**KIRKLEES METROPOLITAN COUNCIL
INVESTMENT & REGENERATION SERVICE**

DELEGATED DECISION TO DETERMINE PLANNING APPLICATIONS

Reference No:	2024/62/90728/E
Site Address:	13, Warburton, Emley, Huddersfield, HD8 9QP
Description:	Erection of two storey rear and single storey front extensions with associated alterations
Recommending Officer:	Elenya Jackson

DECISION - REFUSED

PLANS AS PROPOSED

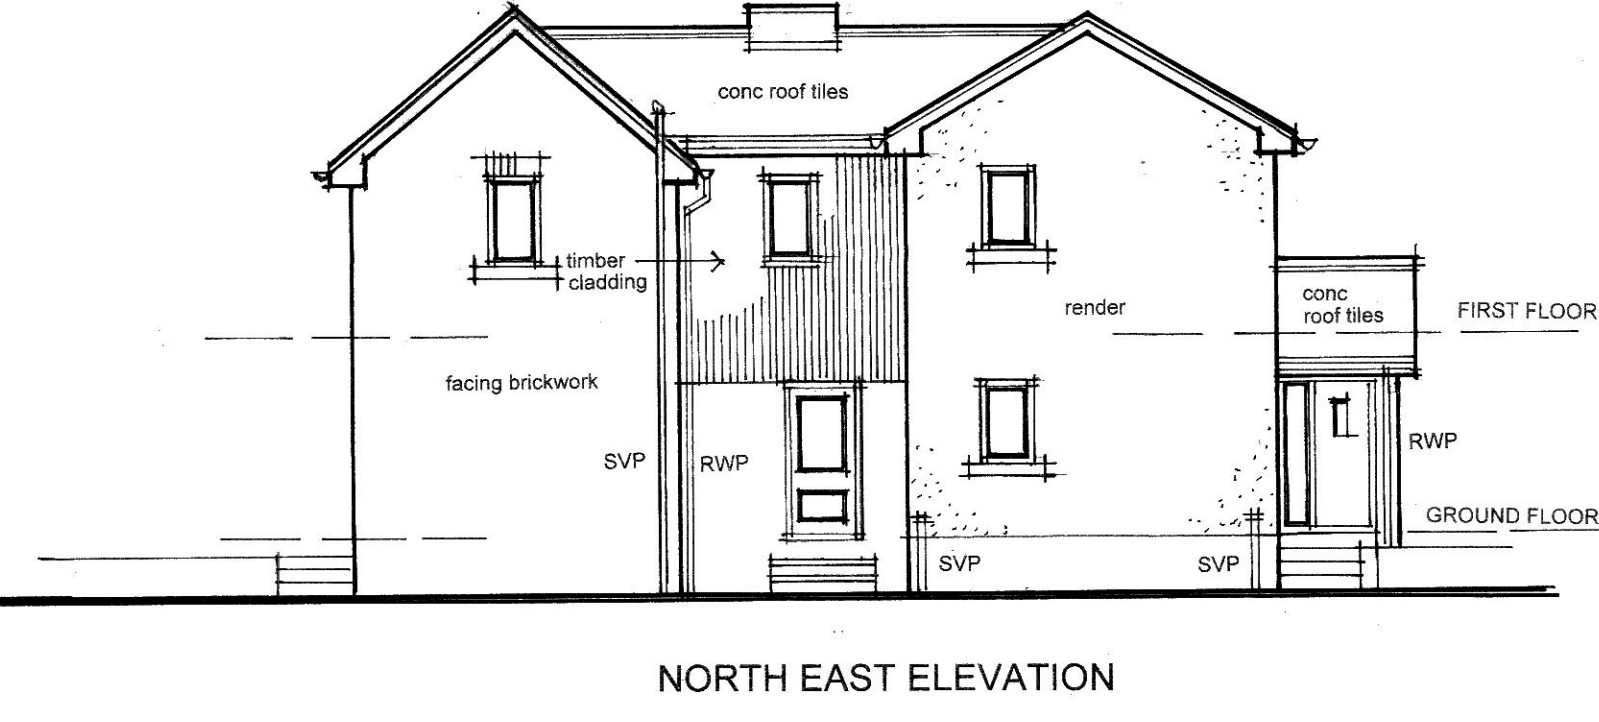
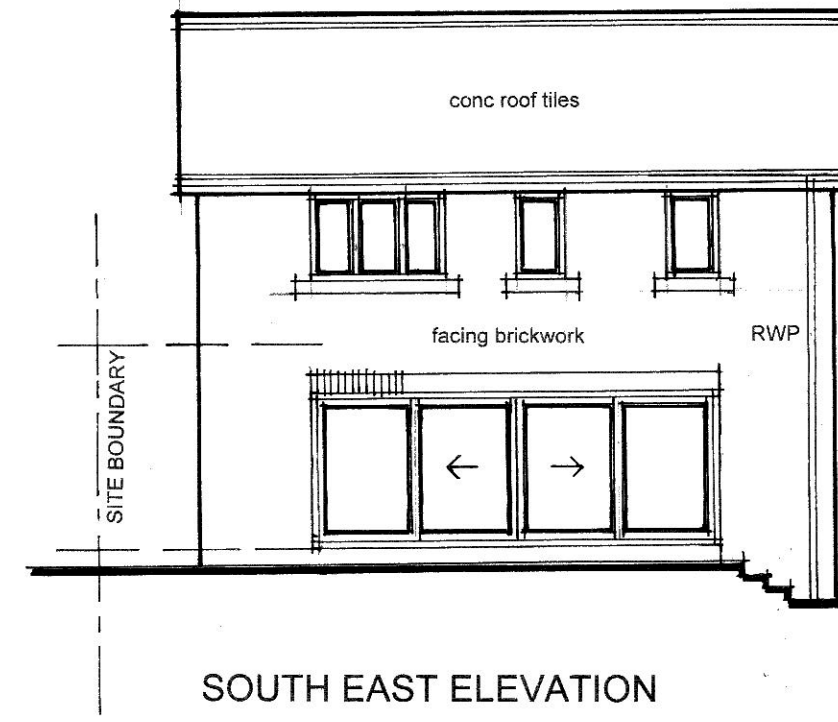
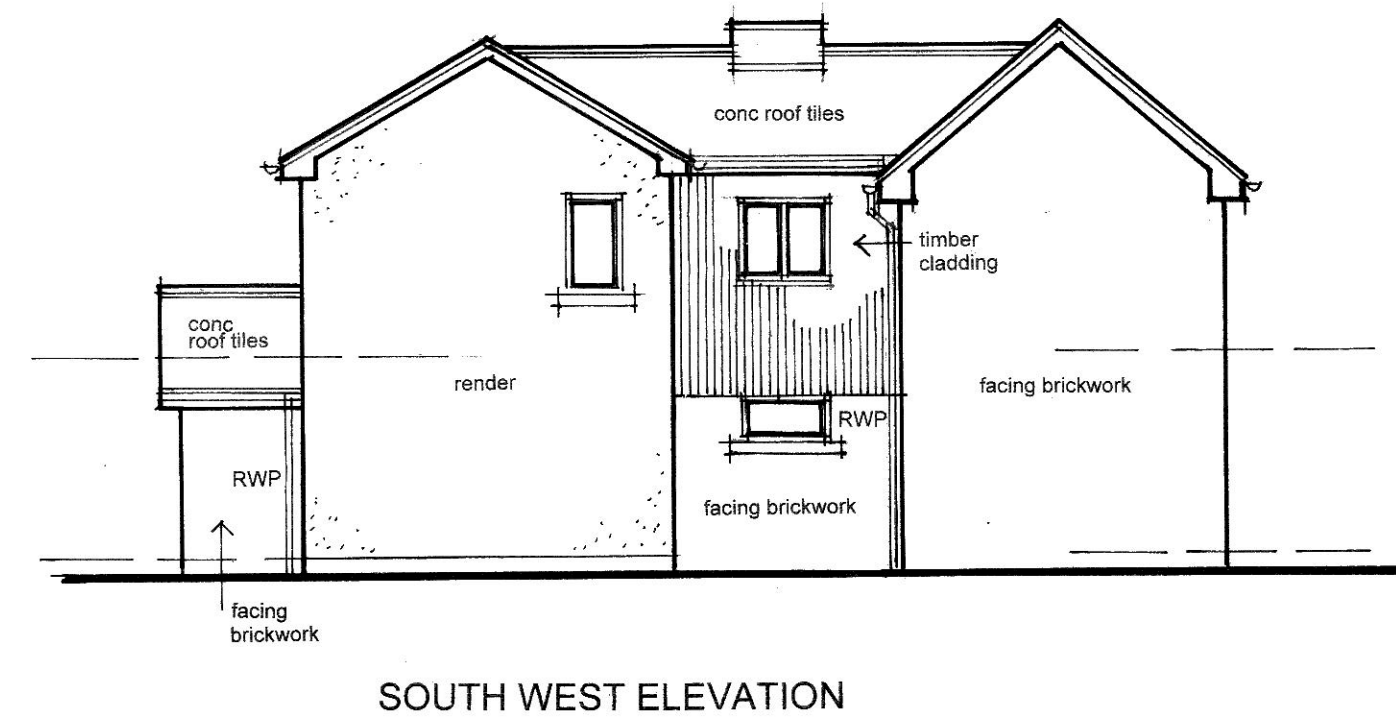
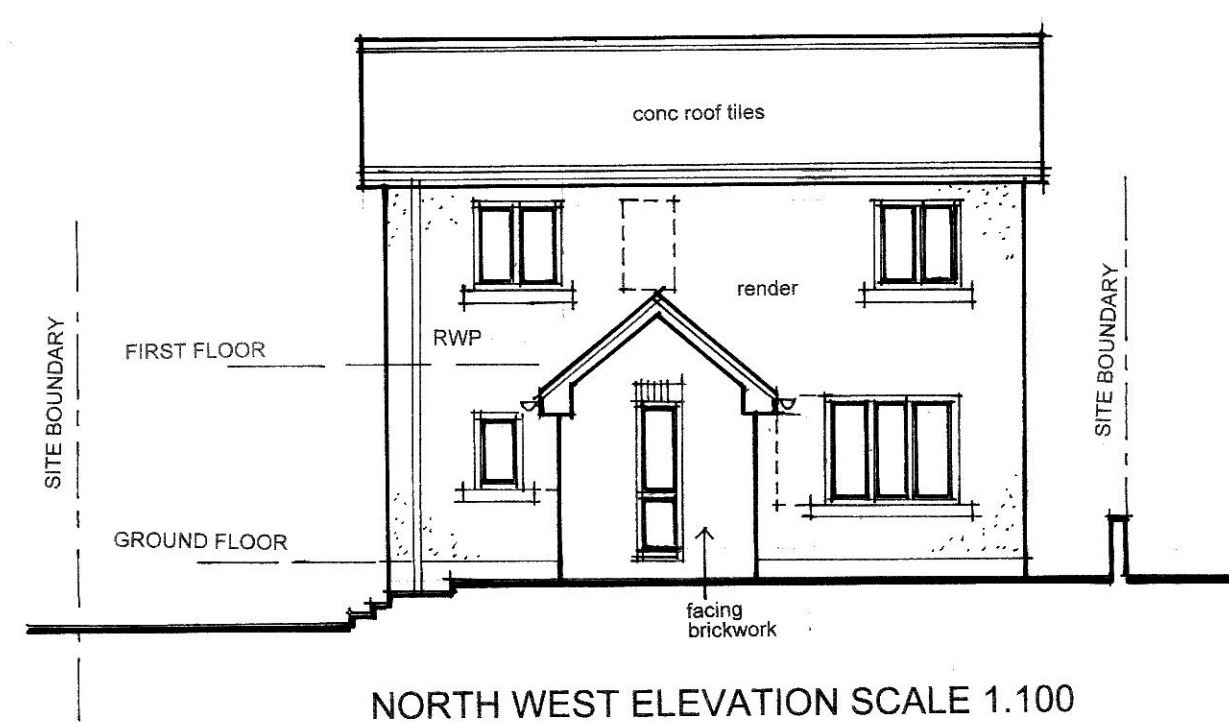
As previously highlighted in the site description, the area is characterised by red brick dwellings with few variations in scale and design. It is considered that the application of render to the property would be an unsympathetic alteration to the host dwelling, the wider street scene and fail to be in keeping with the character of the area.

It is considered that, the proposal by reason of its out of keeping and overly prominent materials would fail to respect the character of the host dwelling and would be read as a discordant feature within the street scene and wider in area. Therefore, the proposal fails to accord with LP 24 of the KLP in terms of the character of the host property and the criteria of the House Extensions and Alterations SPD, particularly KDP 1 & 2 in terms of the character of the area and the impact on the house.

Overlooking: The proposal would feature one additional side facing window at ground floor level and one at first floor level relating to a bedroom. It is acknowledged by officers there is an existing side facing window; however, the additional window would be closer to the rear amenity space of no.15 and would create an additional overlooking relationship. Therefore, the proposal would result in an unacceptable overlooking relationship to the occupiers of no.15.

It is considered that the proposal would have an unacceptable overlooking relationship into the private amenity space of no.15 Warburton contrary to Policy LP 24 of the Kirklees Local Plan, Key Design Principles 3, 5 and 6 of the Kirklees House Extensions and Alterations SPD and guidance contained within Chapter 12 of National Planning Policy Framework

In addition, due to the introduction of a first floor window it would result in unacceptable impact to the residential amenity of the occupiers of No.15 Warburton contrary to Policy LP 24 of the Kirklees Local Plan, Key Design Principles 2 and 6 of the Kirklees House Extensions and Alterations SPD and guidance contained within Chapter 12 of National Planning Policy Framework.
